EL PASO COUNTY GRADING AND EROSION CONTROL PLAN CHECKLIST

PPR2227

GENERAL NOTES
 DUNKIN BENT GRASS
 SITE DEVELOPMENT PLAN
 LOT 1A, BENT GRASS EAST COMMERCIAL FILING NO. 2A,
 LOCATED IN TOWN OF PEYTON,
 COUNTY OF EL PASO, STATE OF COLORADO

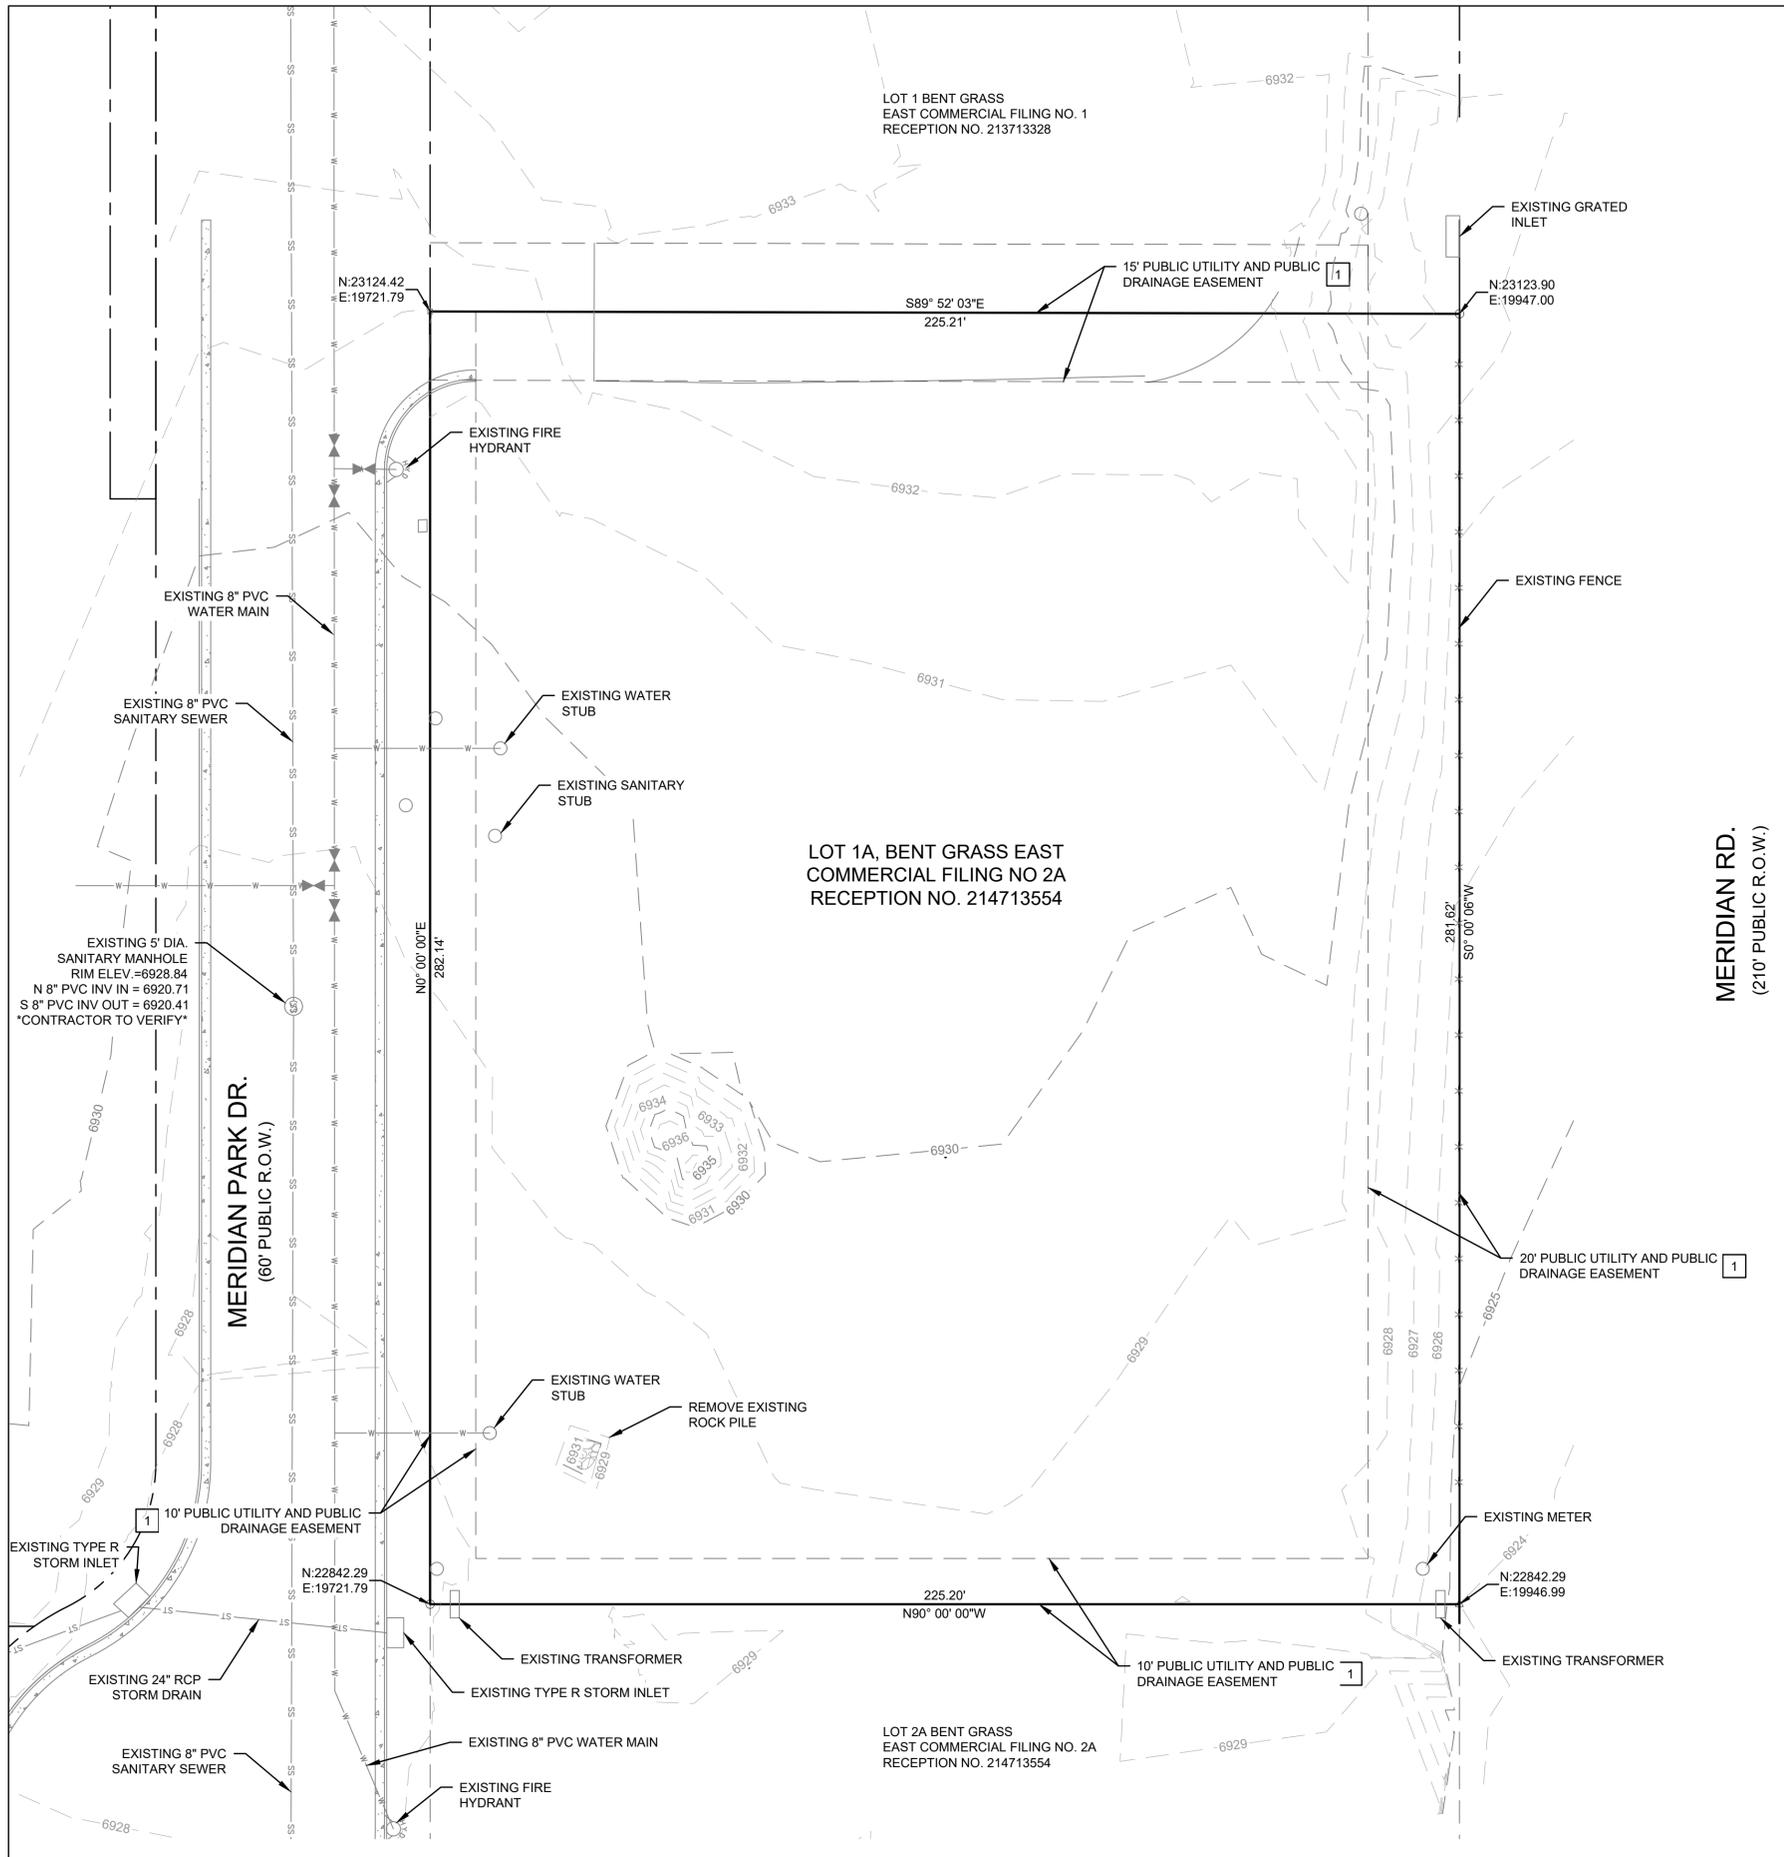
Is the GEC going to be a standalone doc or included with the CD's. Right now they appear to be excerpts from the CD's (based on the Sht #'s). Once you decide, update which one of these signatures will be used.
